RECOMMENDATION FOR PLANNING AND DEVELOPMENT COMMITTEE

REFUSAL

APPLICATION REF: 3/2024/1016

REGULARISATION OF WORKS INCLUDING EXTENSION TO GROUND FLOOR TO INCLUDE INTERNAL SECURE RESIDENTS CYCLE STORE WITH ROLLER SHUTTER DOOR; RE-INSTATE REAR BOUNDARY WALL TO 0.74M HIGH; ALTERATIONS TO REAR EXTERNAL STAIRCASE; UPVC WINDOWS AND DOORS TO FRONT, SIDE AND REAR; ALUMINIUM WINDOWS TO THE FRONT DORMER; SCREENING FEATURE TO THE REAR BALCONIES; GROUND FLOOR BIN STORE; CENTRAL CLADDING TO FRONT DORMER WINDOW ON THIRD FLOOR; ROOFLIGHTS; EXTERNAL LIGHTING SCHEME TO REAR AND TWO ELECTRIC CHARGING POINTS AT 1 TO 7 THE PICTURE HOUSE, GEORGE STREET, WHALLEY BB7 9TH

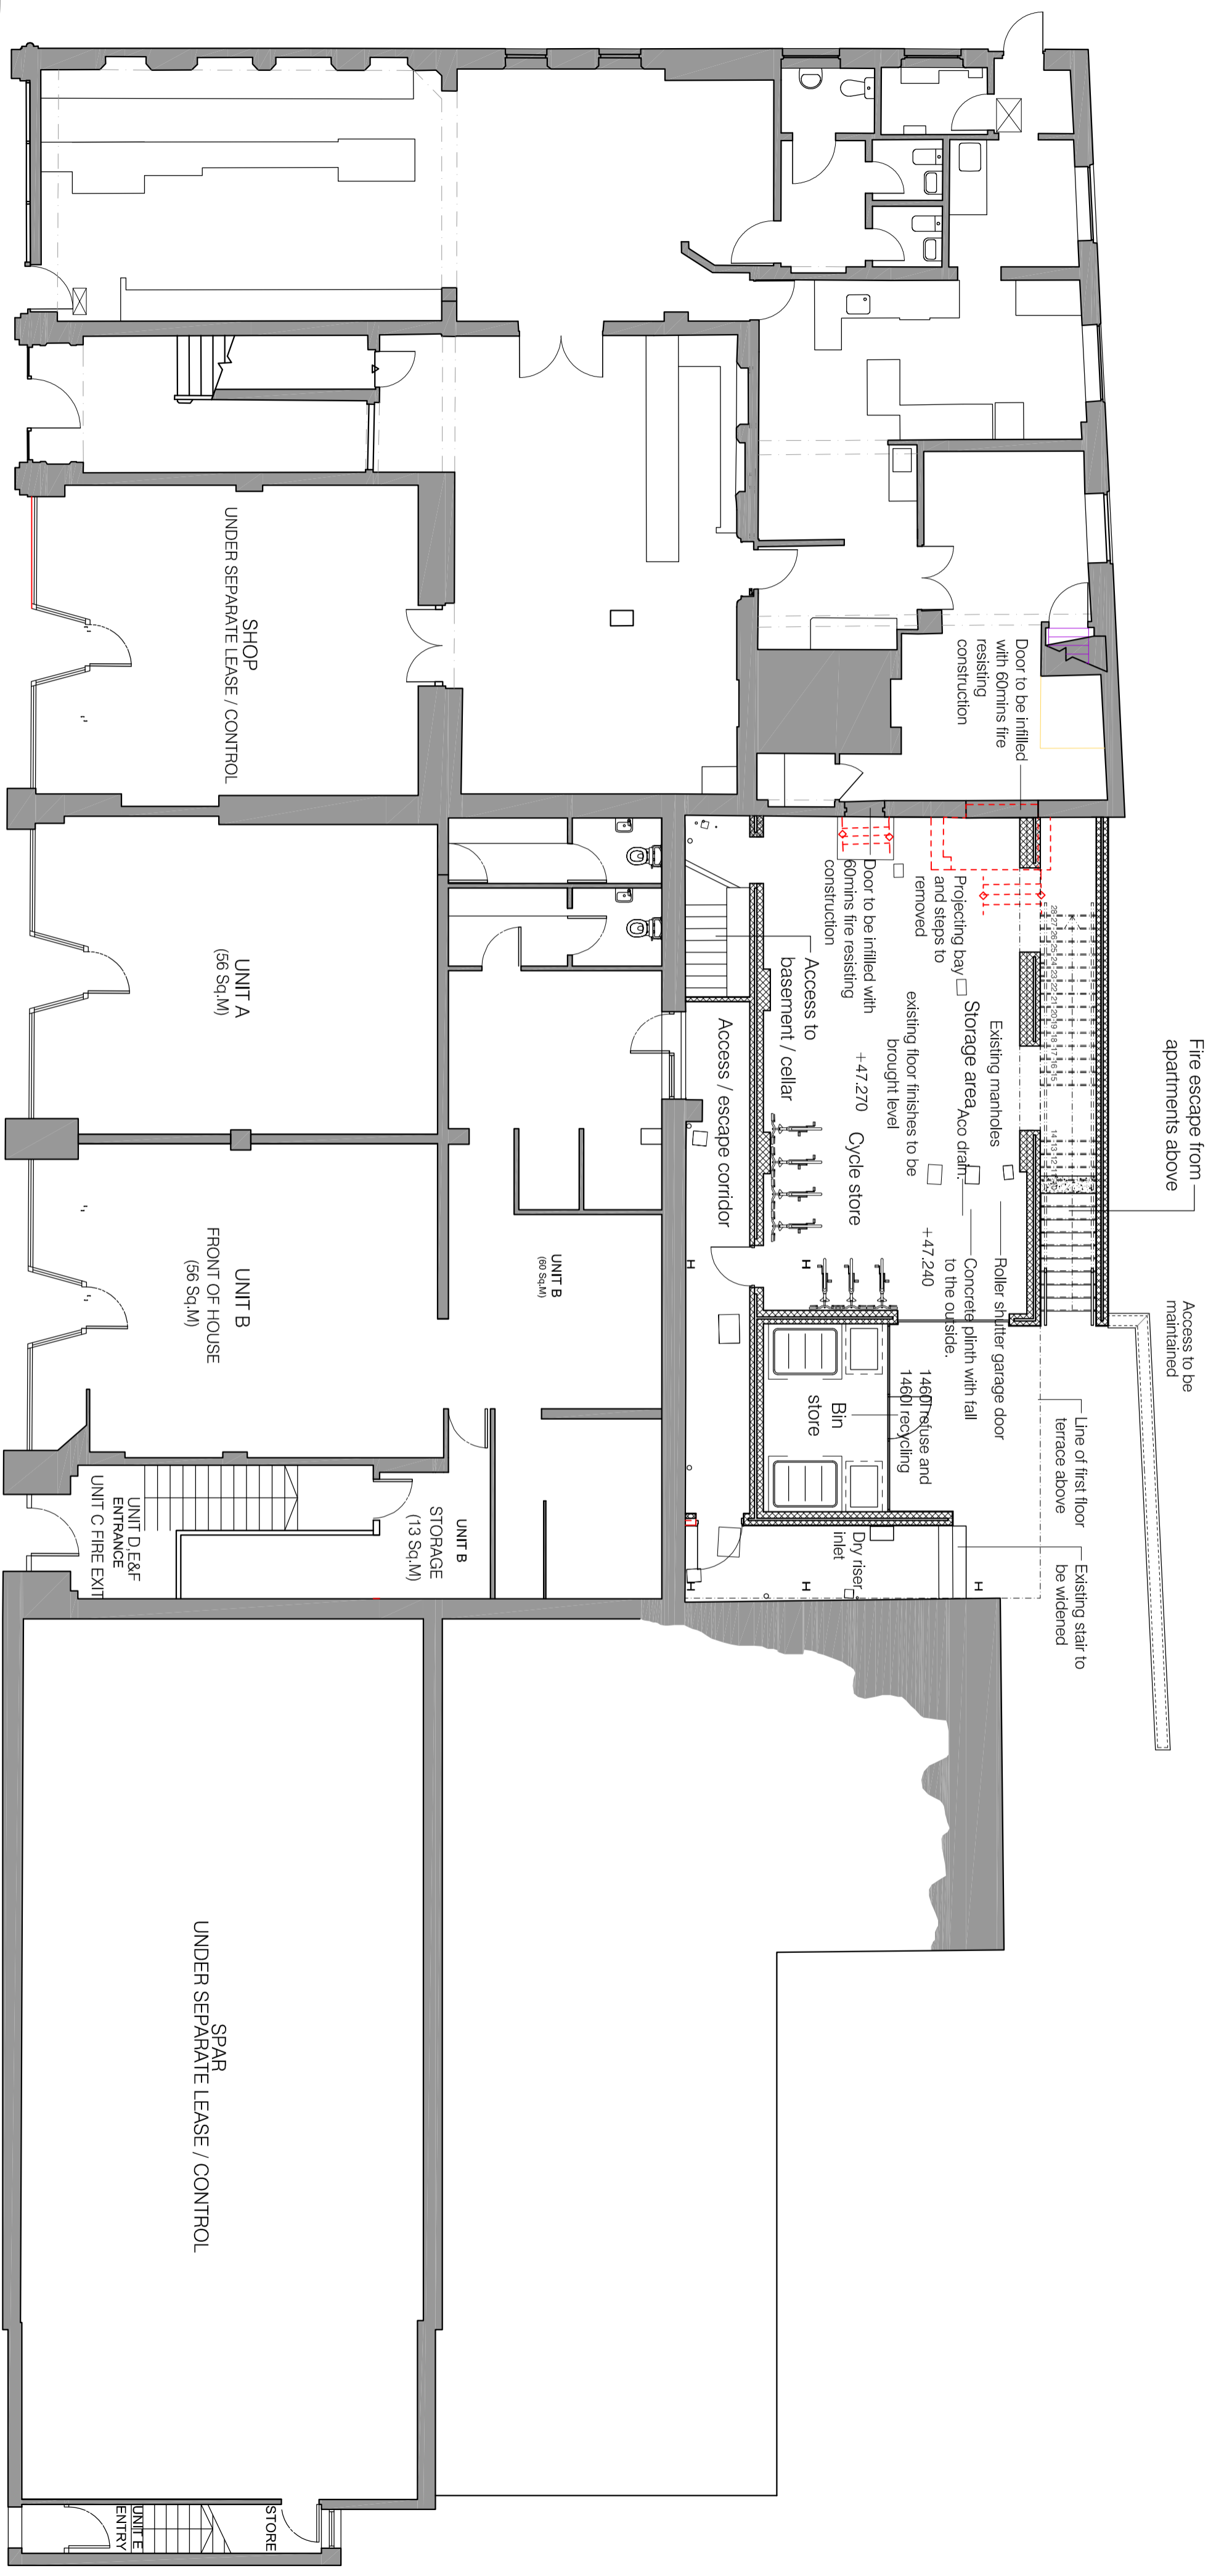
The LHA has reviewed drawing number 2232-100 AB titled Proposed ground floor plan and noted an extension to the ground floor supports bin storage as well as cycle storage which is secure and provides one cycle space per apartment which is acceptable.

- Rear Ground Floor Extension and Secure Cycle Store – introduces a significant change to the existing footprint which raises concerns about its scale and impact on the surrounding area. The roller shutter is incompatible with the building aesthetics in a conservation area and would negatively affect the visual amenity of the area, particularly when viewed from neighbouring properties;

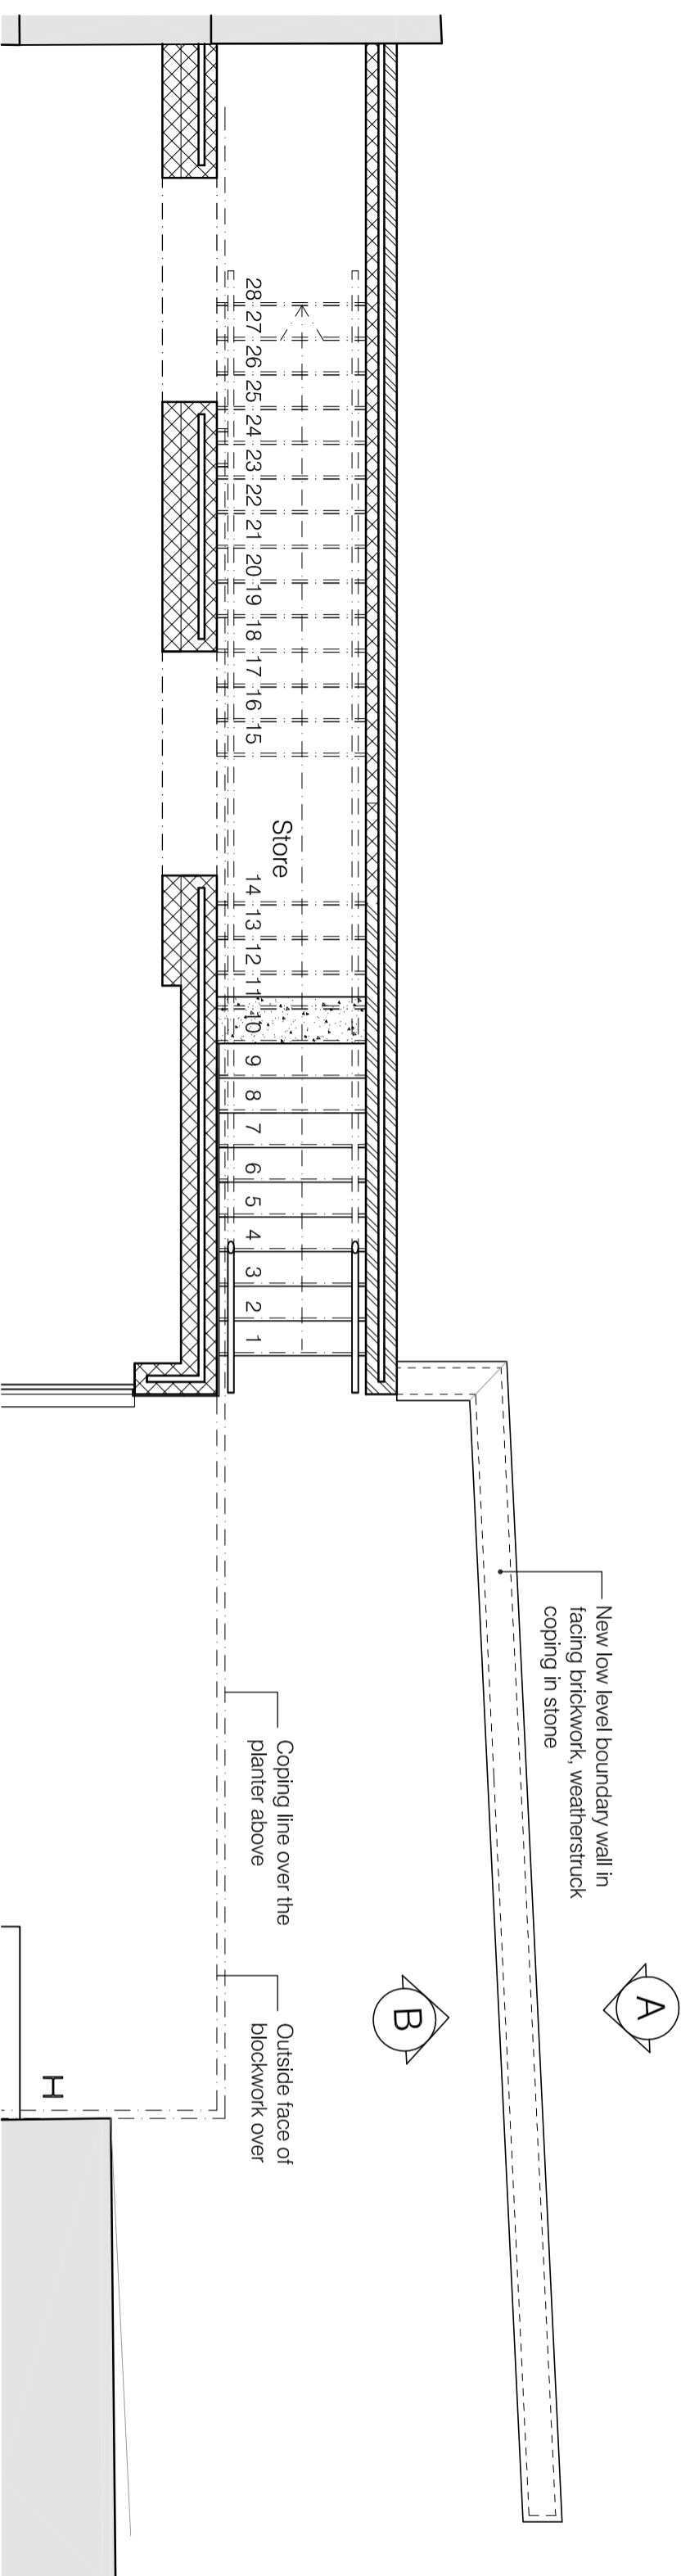
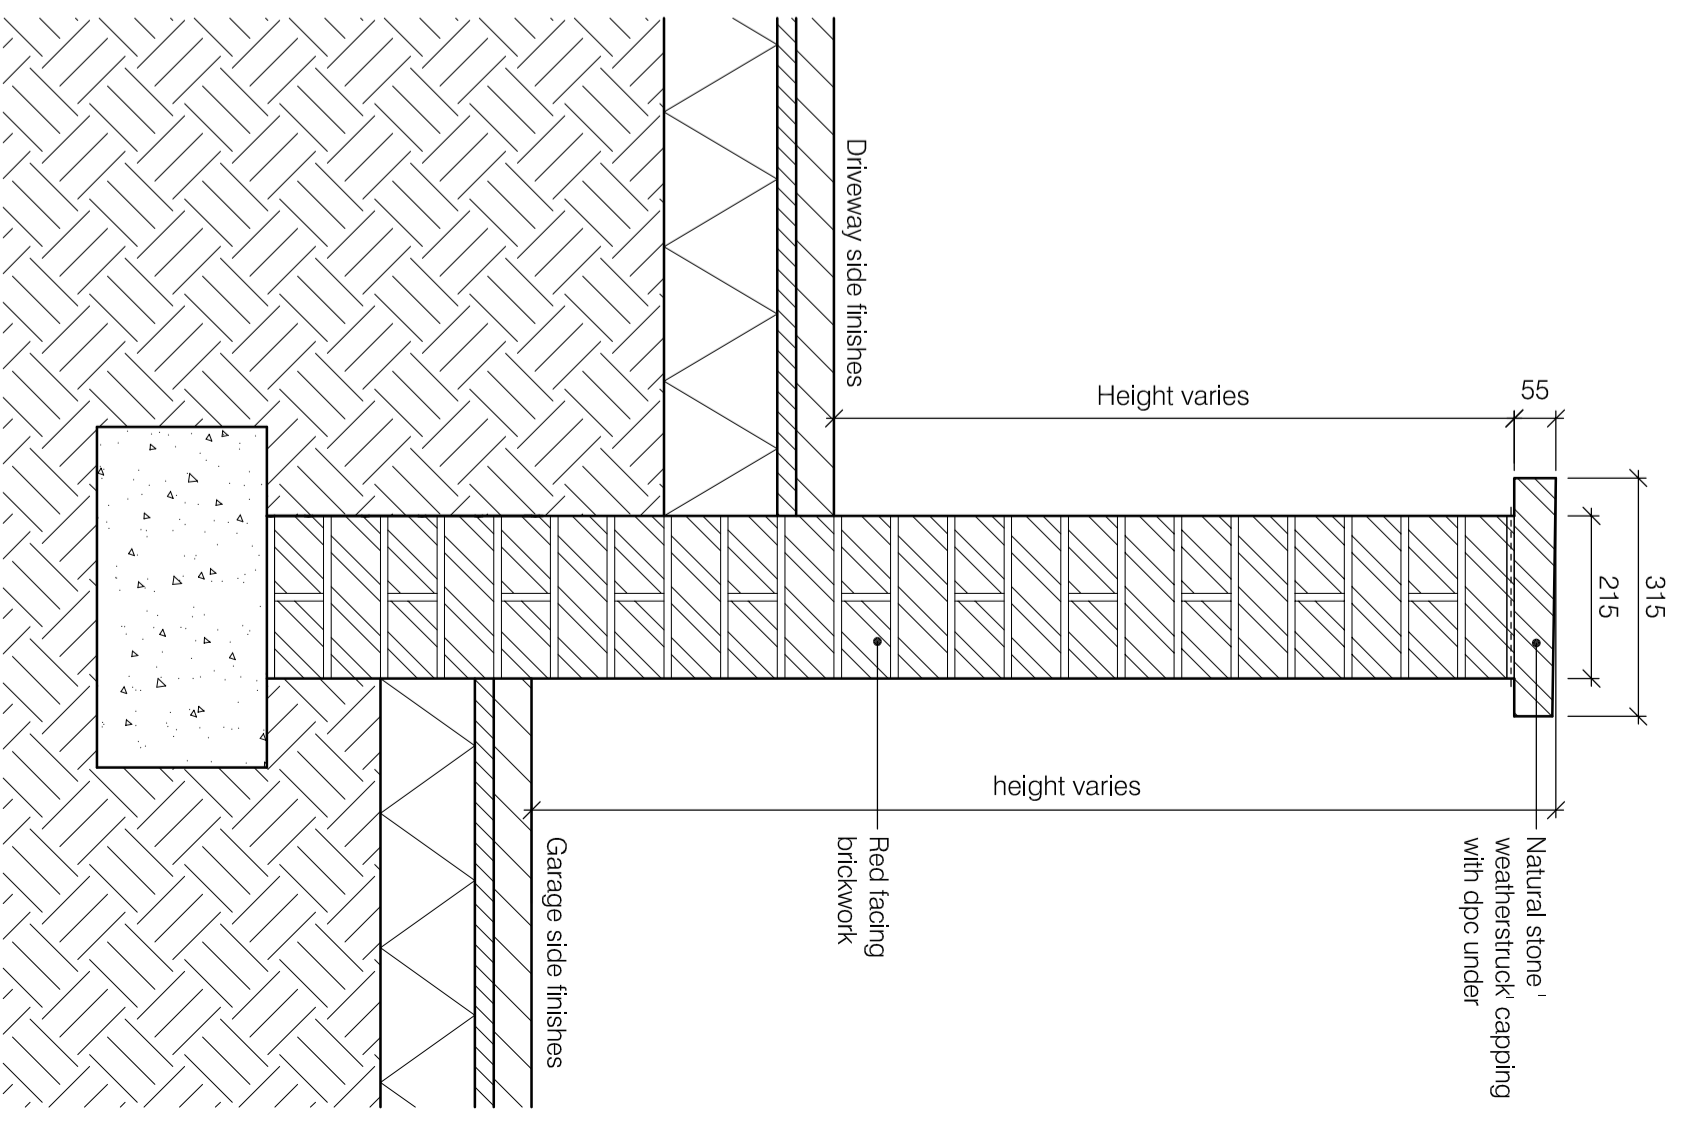
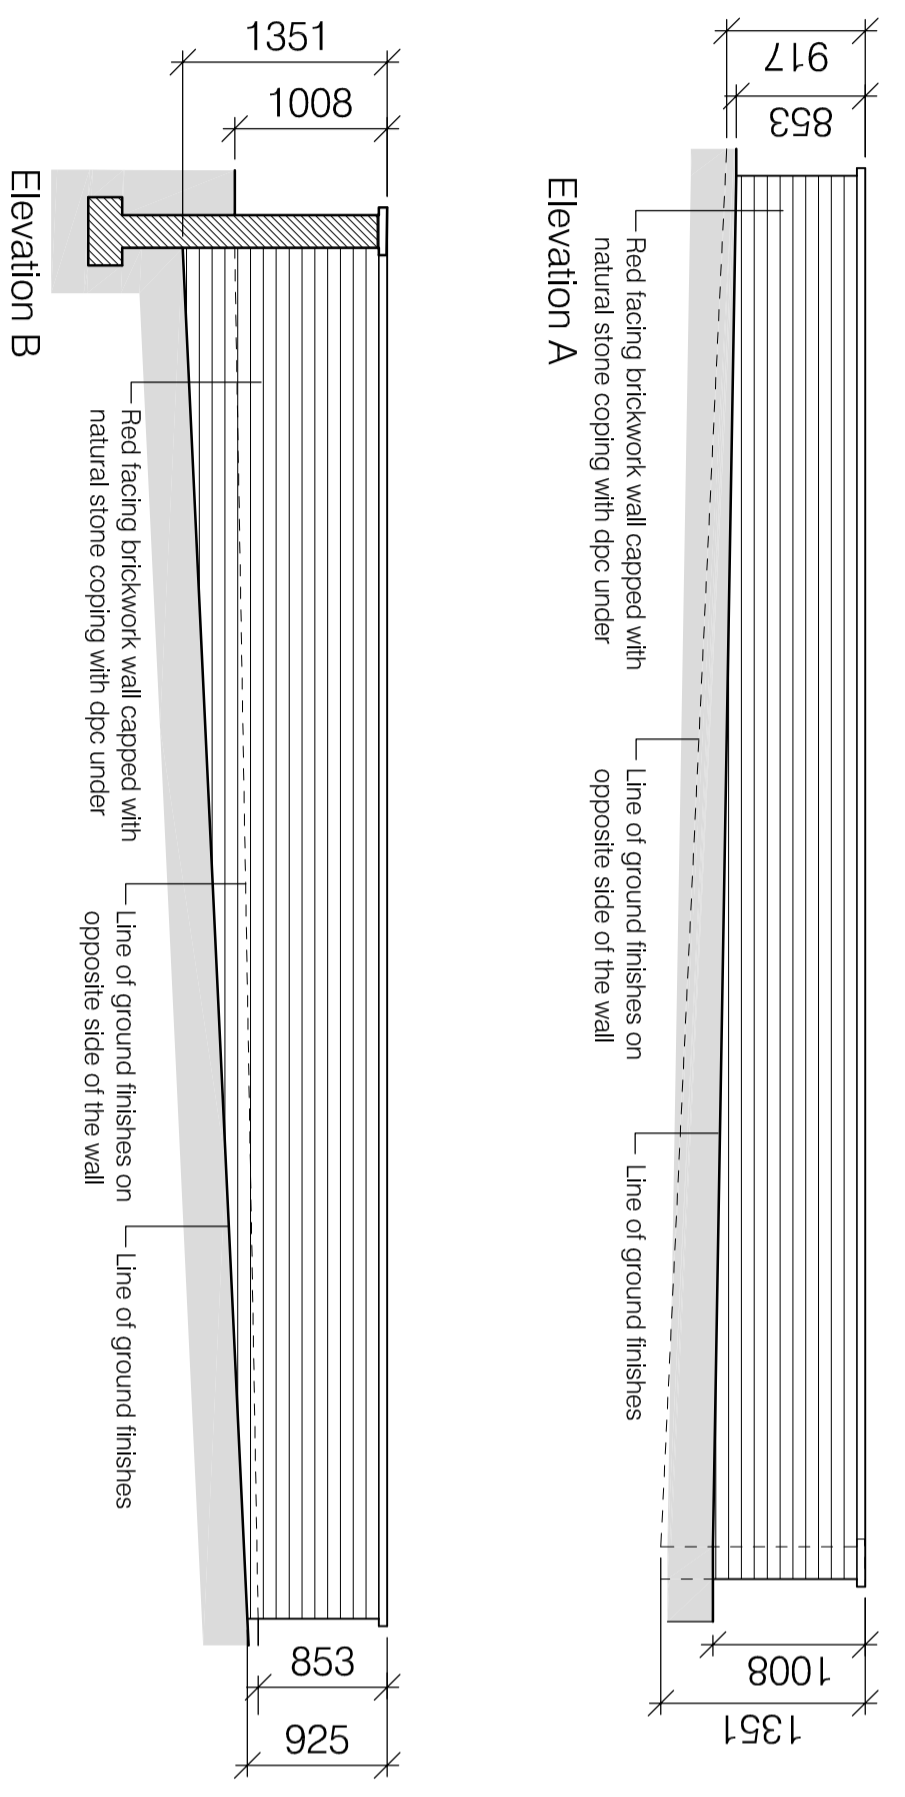
- Rear Boundary Wall – the restatement of the wall while claimed to match the original footprint raises significant concerns. The height is disproportionate to the character of the area and further encloses the space. It has not been demonstrated that it is necessary or proportionate in terms of benefits;

2.2 The replacement rear boundary wall has been described as 0.74m high however on site it was apparent that the wall as constructed is higher. The agent has been requested to clarify this. Any update will be provided to the meeting.
